CITY OF ALBUQUERQUE

PLANNING DEPARTMENT – Development Review Services

RE: Anasazi Ridge, Unit 3 (File: A10D002G)
Drainage Report, Engineer's Stamp Date 1-12-2015
Supplemental Rundown Calculations, Engineer's Stamp Date 2-3-2015
Grading and Drainage Plan Engineer's Stamp Date 3-4-2015

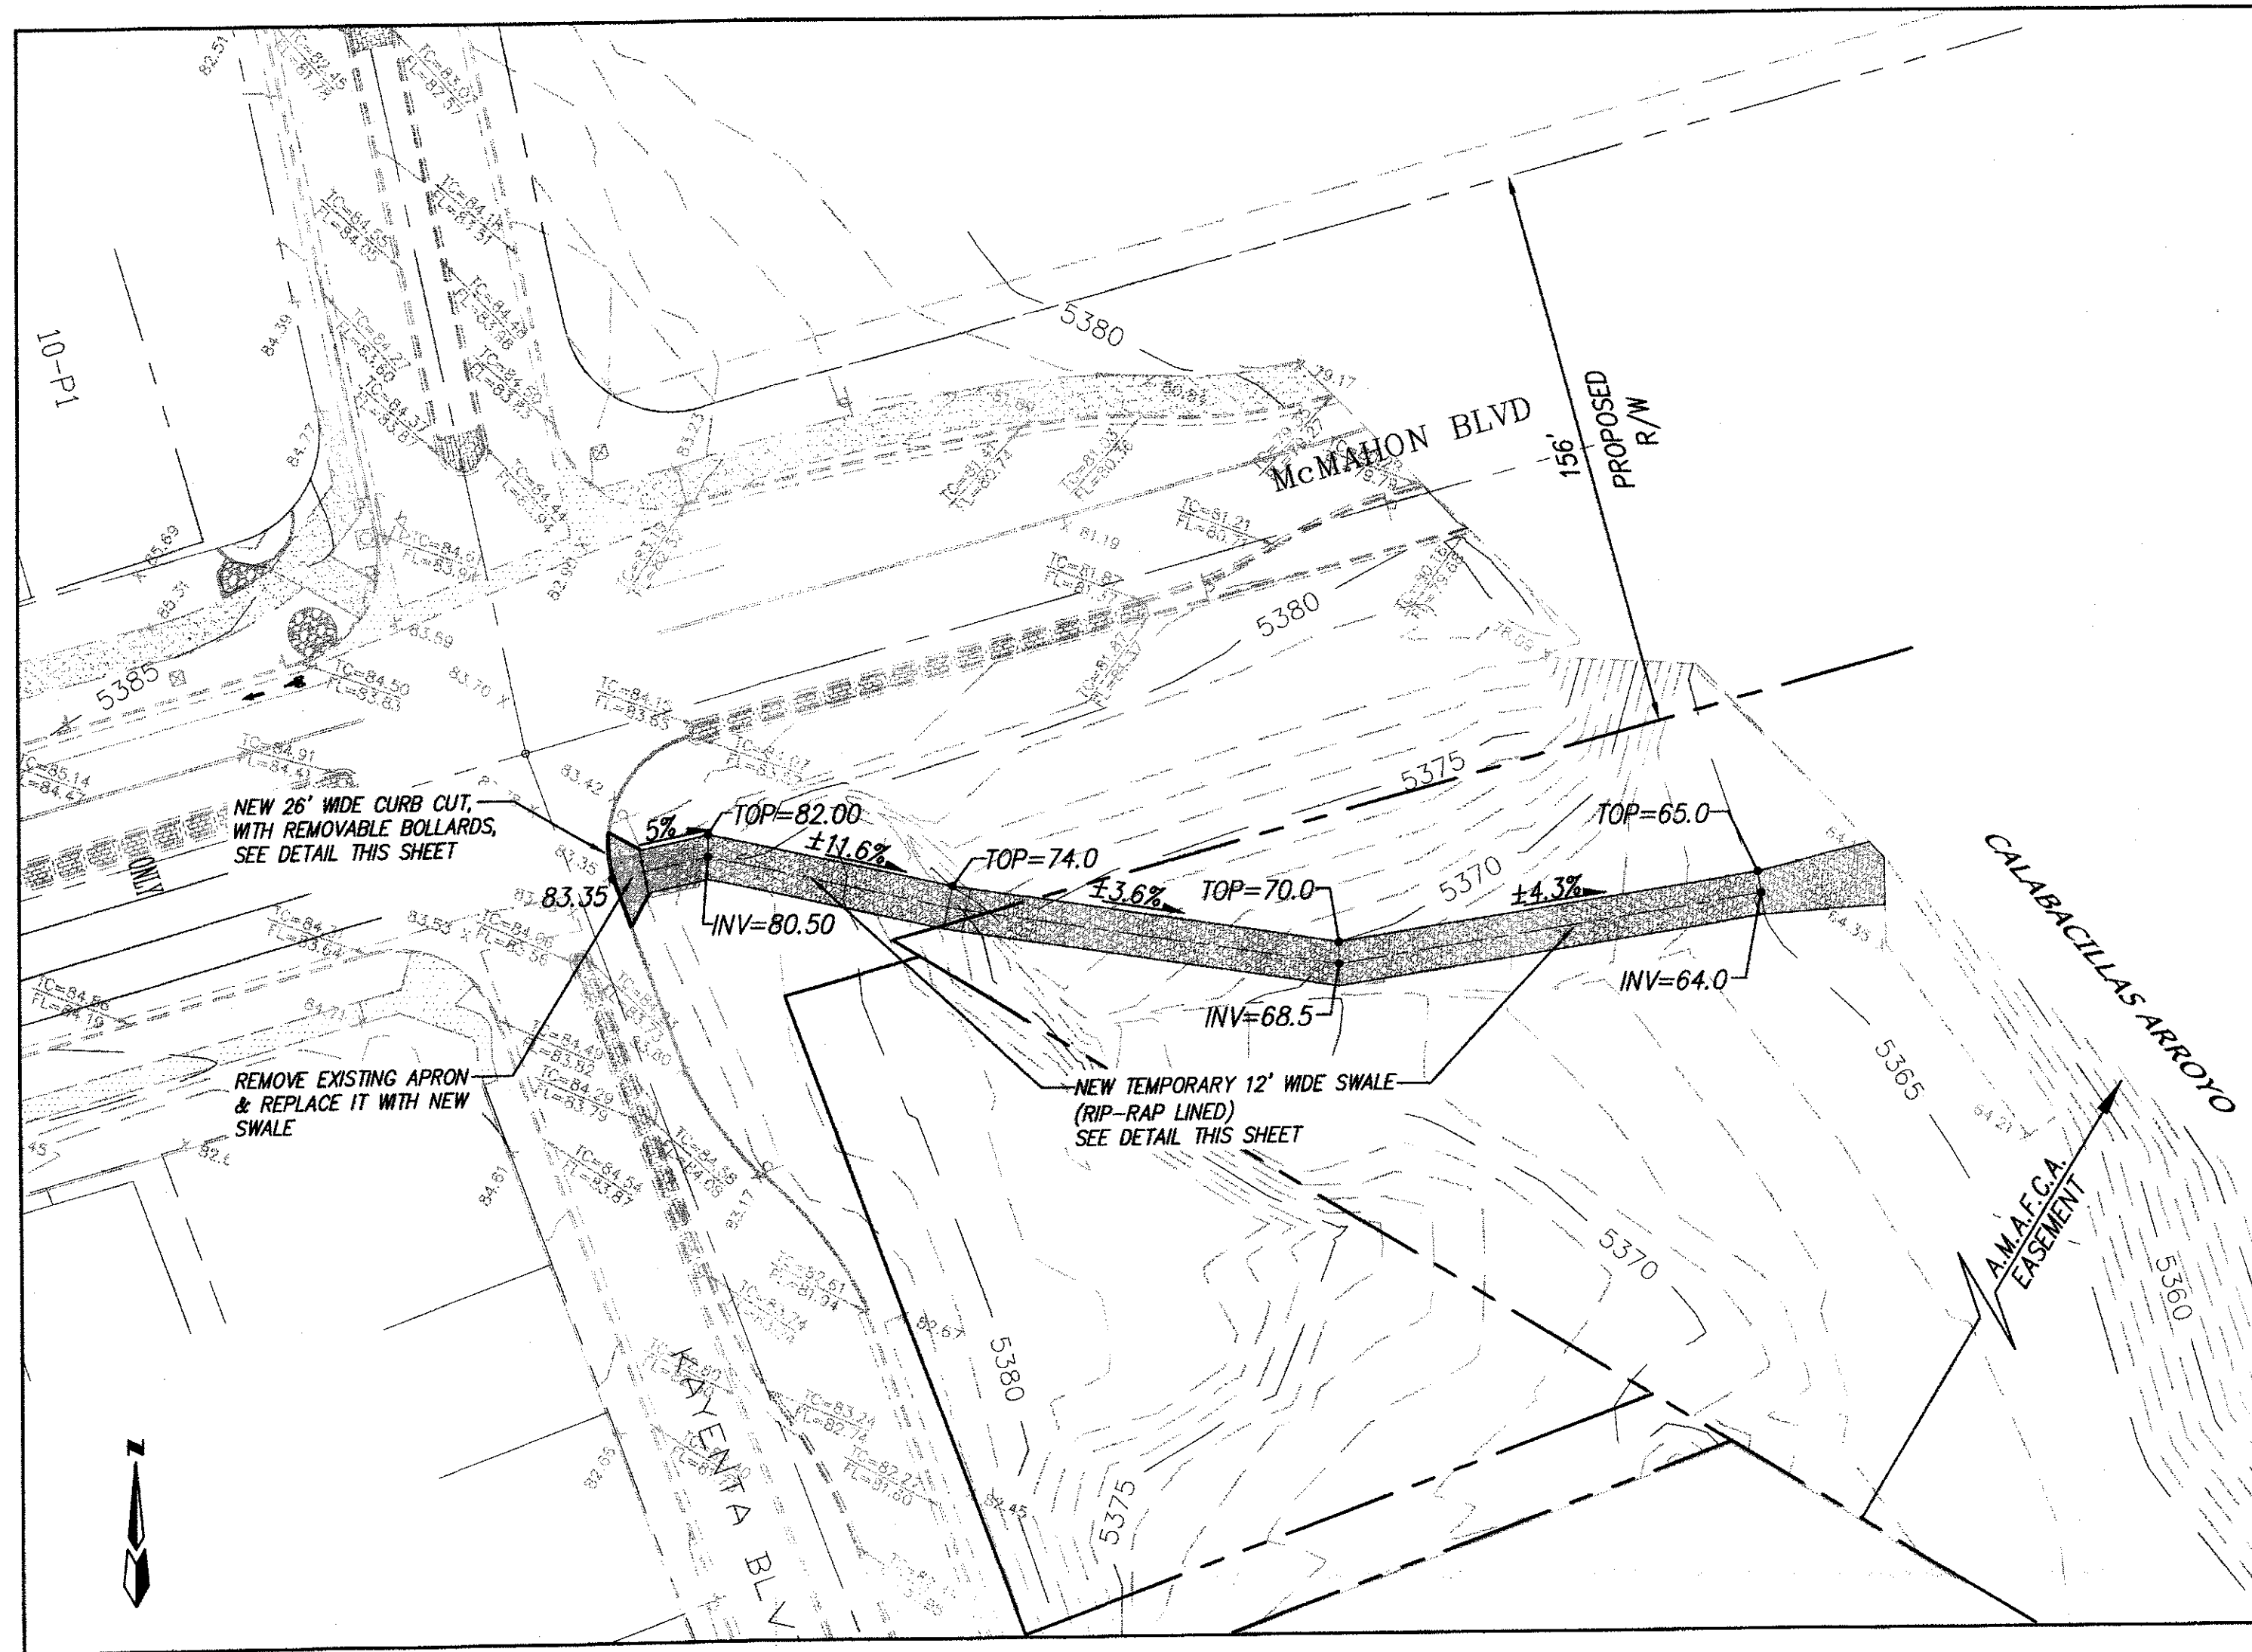
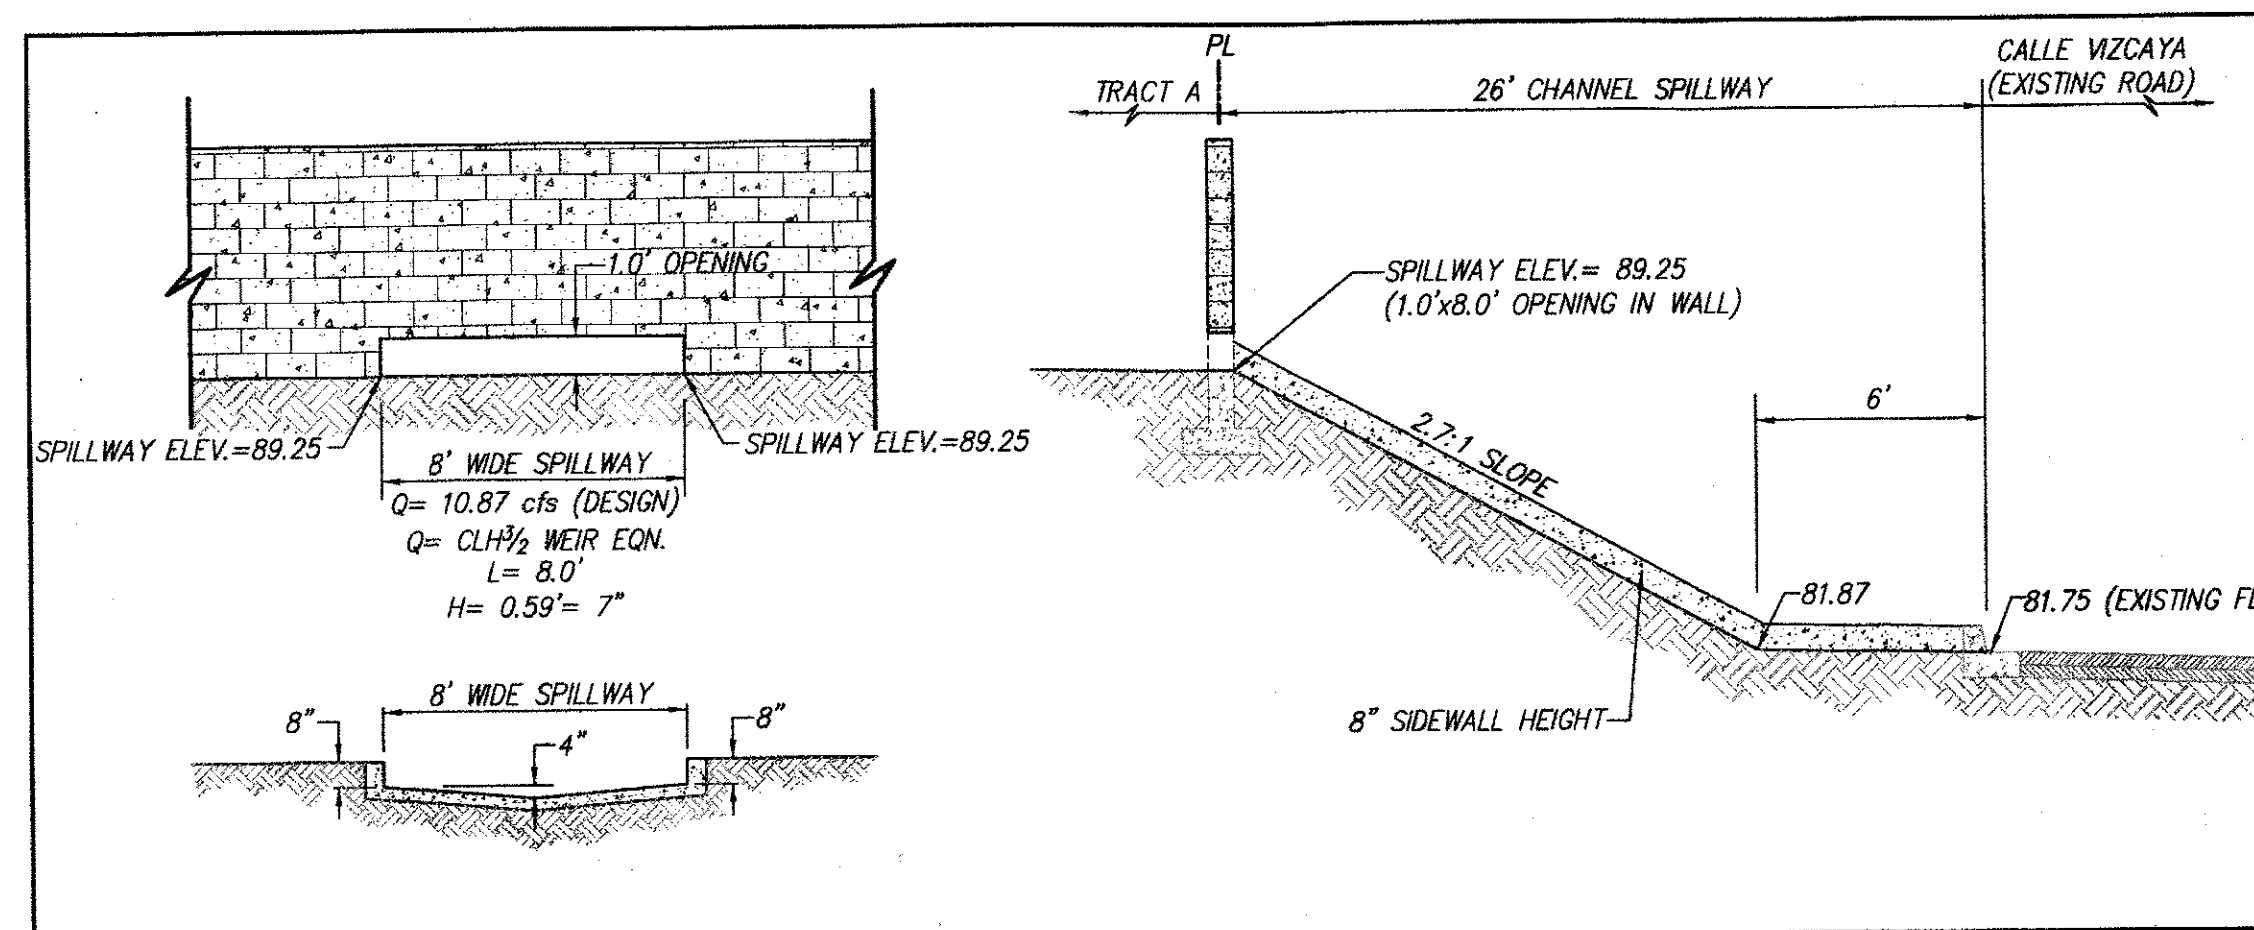
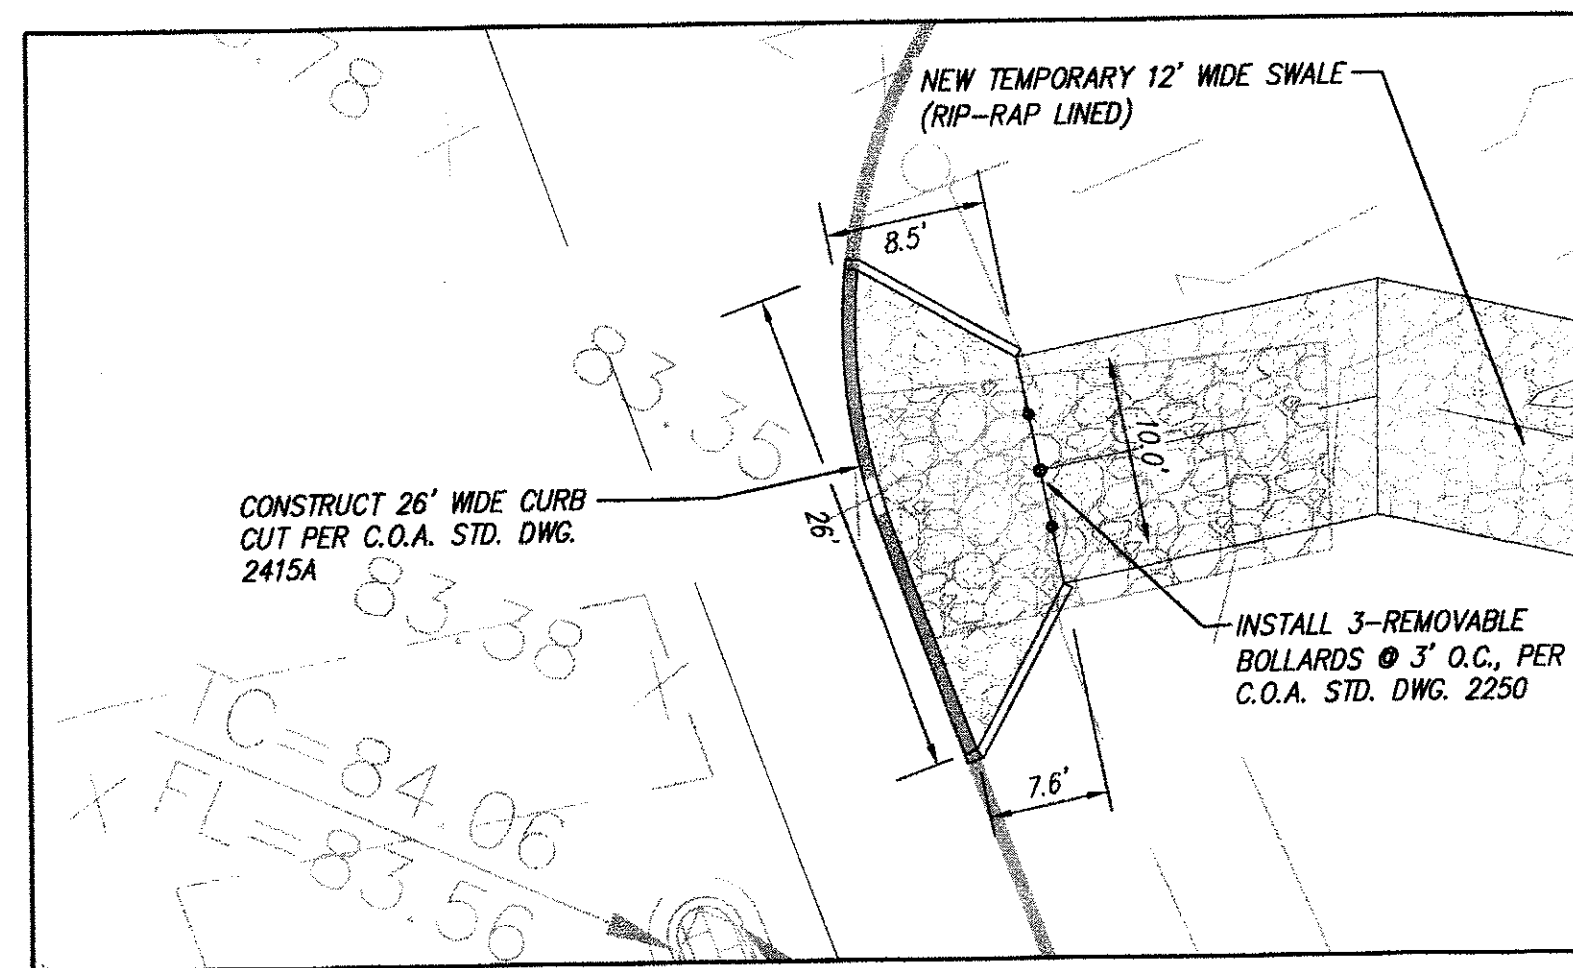
- It is understood that Tract A, B, and C have been incorporated into the adjacent lots. Remove the Tract labels on the Engineer's Certification plan.
